FW: FG/16/26/NMA - 4 SOUTH DRIVE

Please upload the attached as an amended plan – replacing ID 6 – Block Plan

Site Plan as Proposed

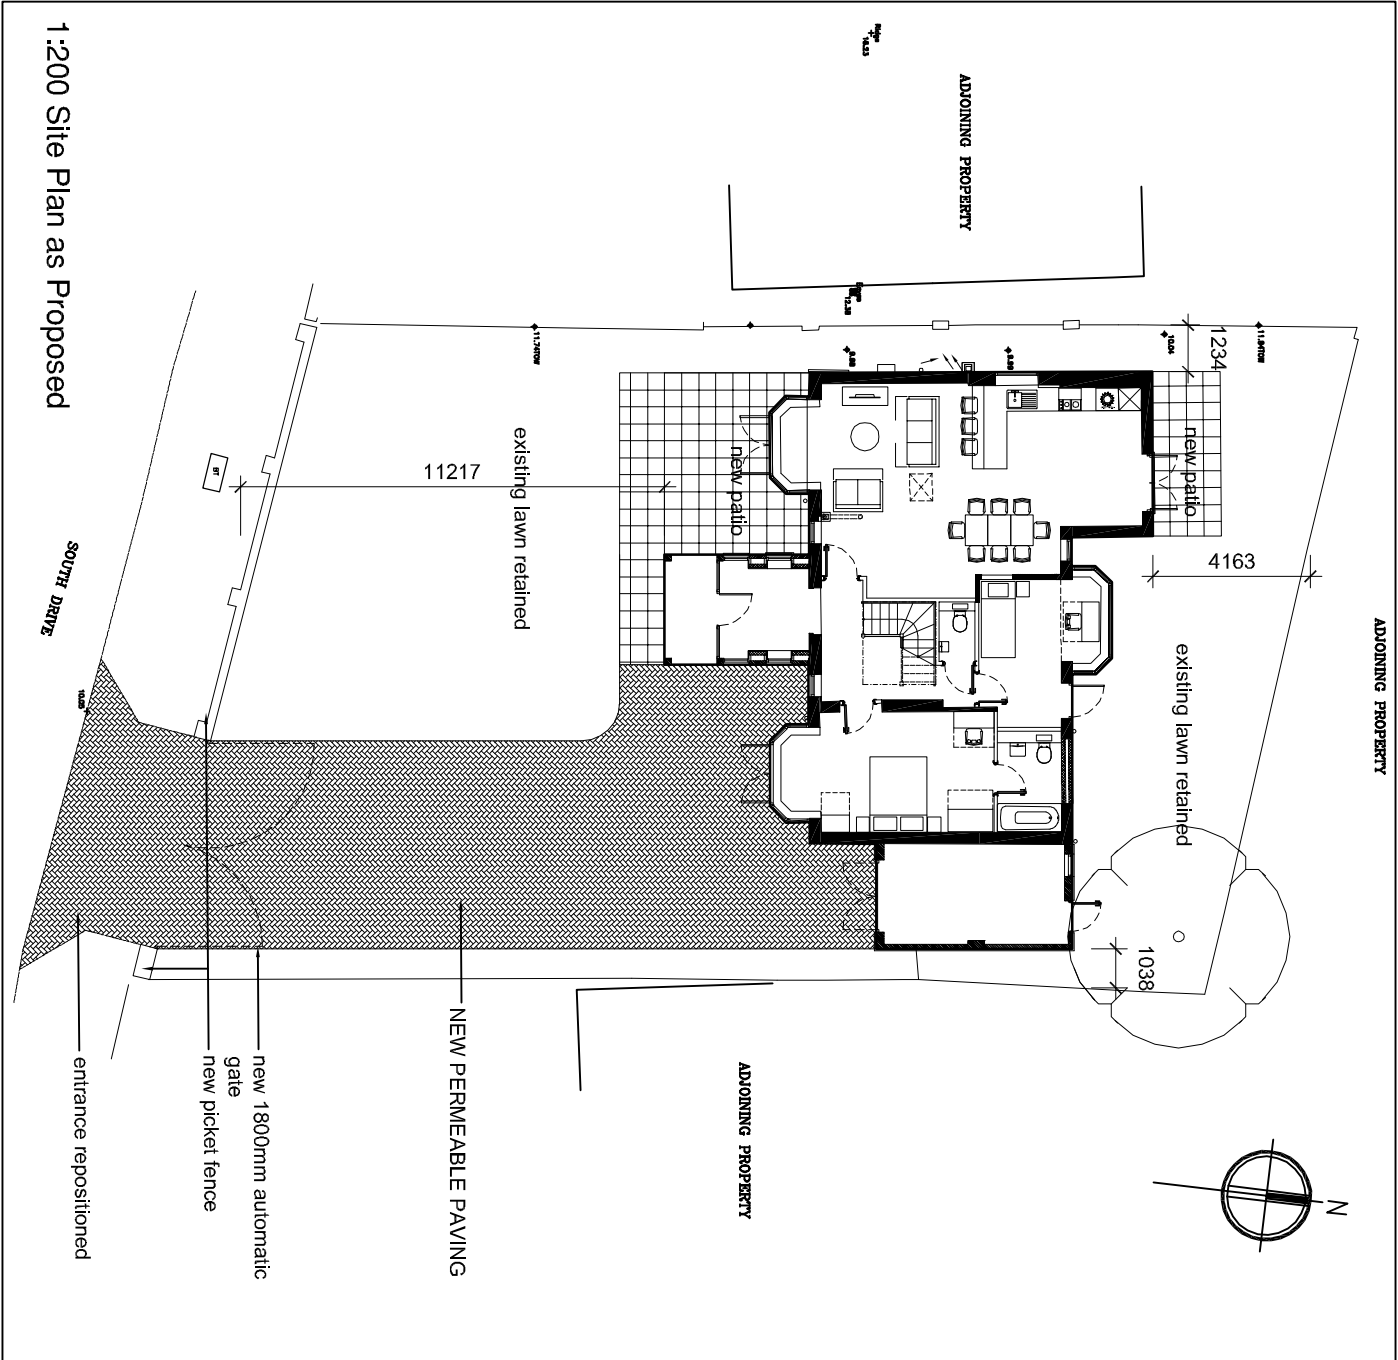
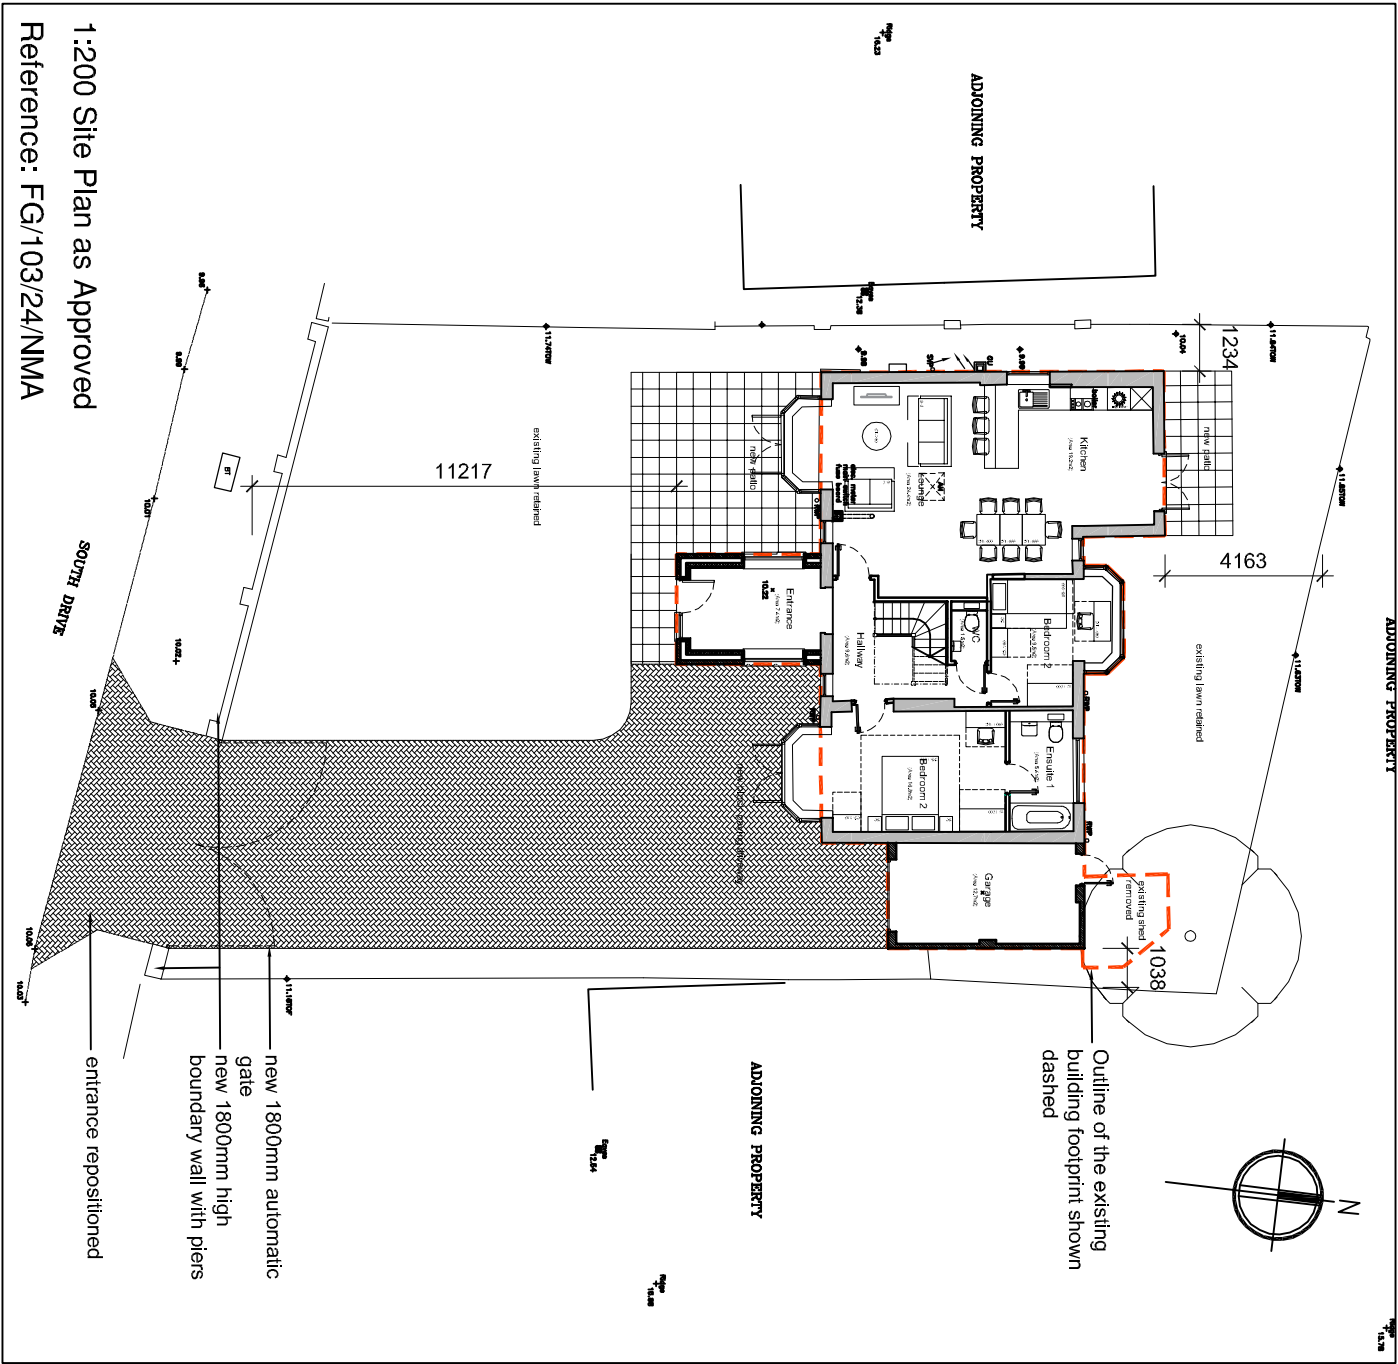
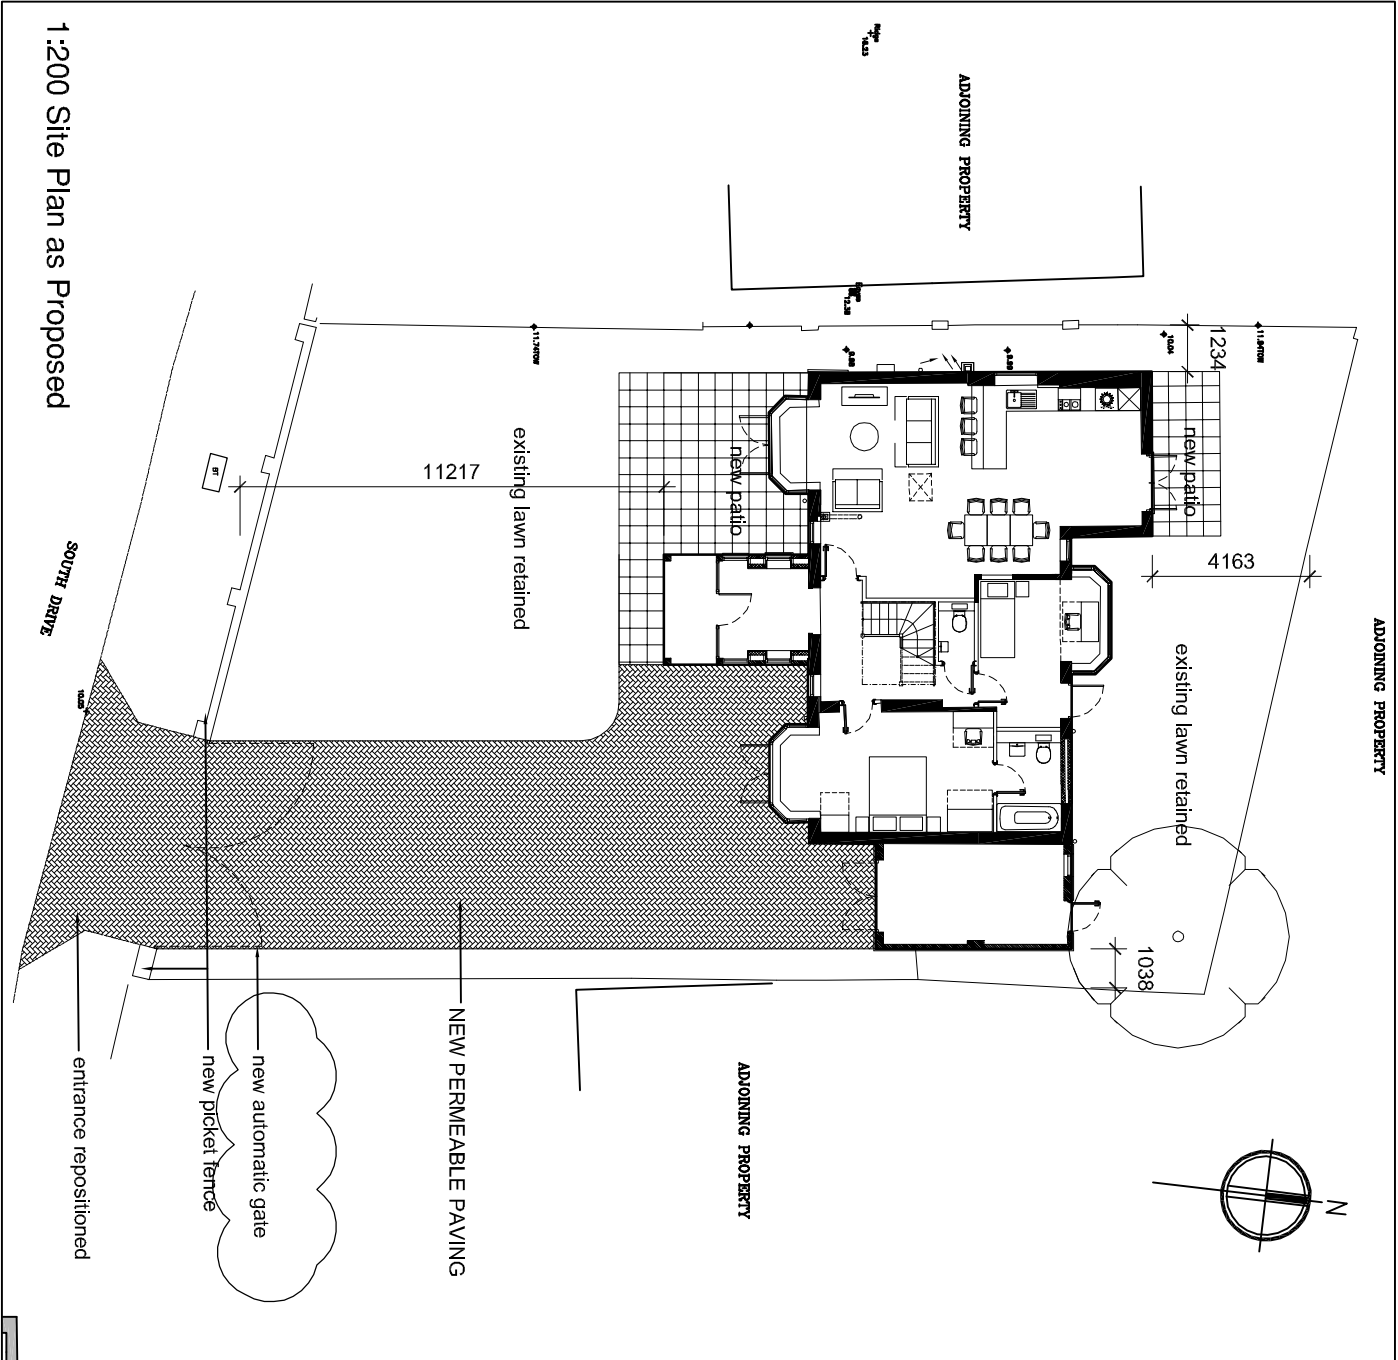
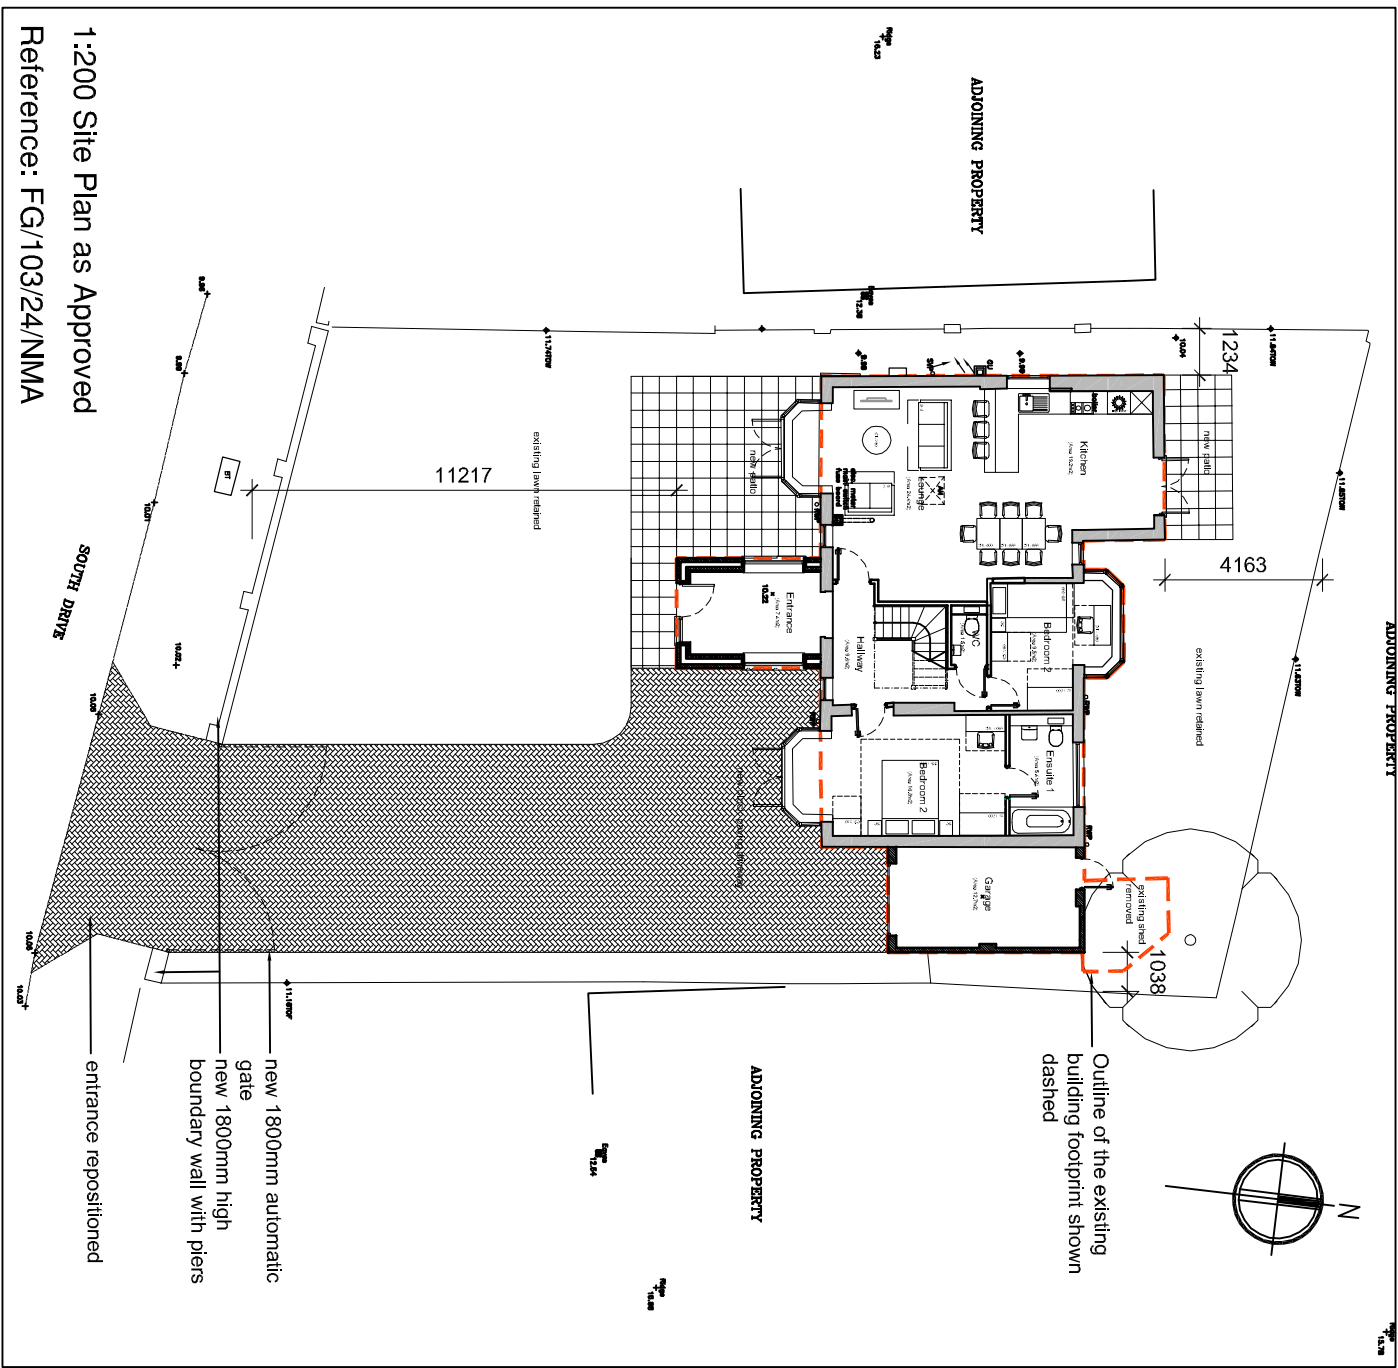
Please could you amend the Proposed site plan. The annotation makes reference to 'new 1800mm automatic gate' however the drawing has the height at 1215mm.

Please amend the plans to correct this discrepancy.

Thanks for noticing this discrepancy. We have removed the incorrect information. The amended drawing is attached.
